KITTITAS COUNTY

November 15, 2016

County Survey review of Boundary Line Adjustment 16-00016 (Haagens)

LOTS 1 THROUGH 8, HAAGEN'S REPLAT  
PART OF SECTION 1, TOWNSHIP 17 NORTH, RANGE 18 EAST, W.M.

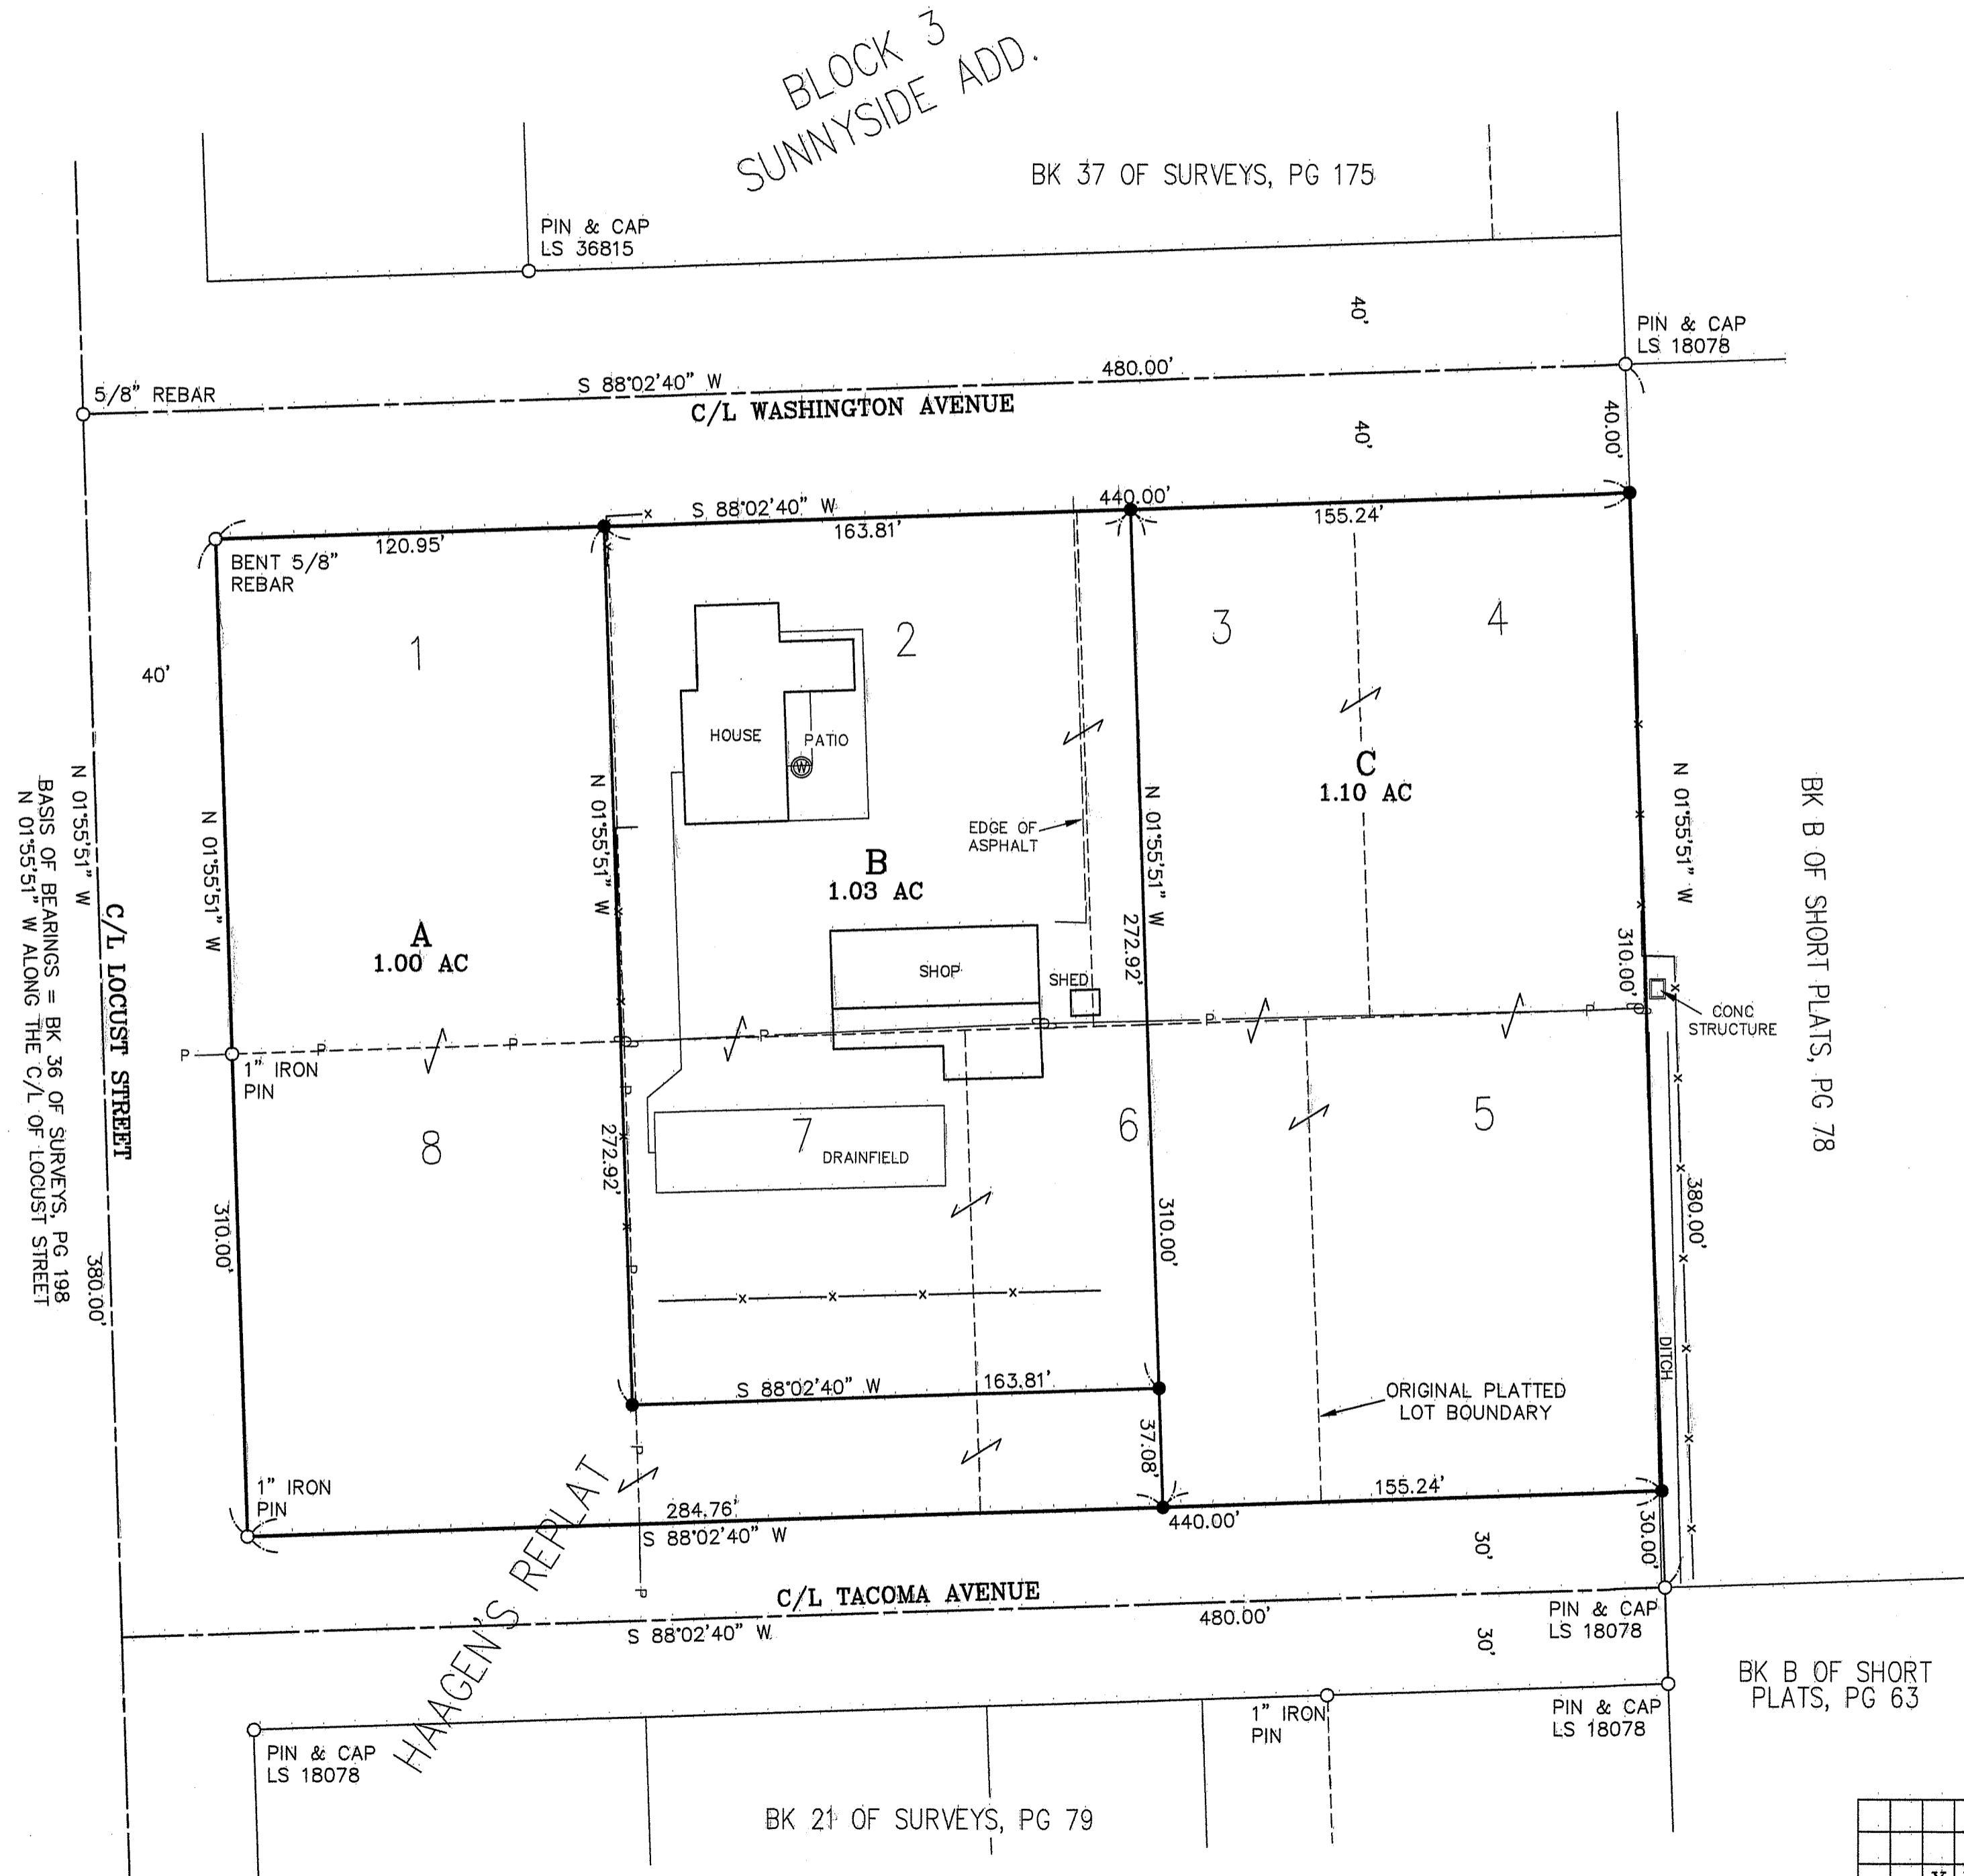
1. All roadways must show road name, width, underlying ownership, Easement or Right of way, and surfacing material. (Locust St - 80' County R/W – Paved)
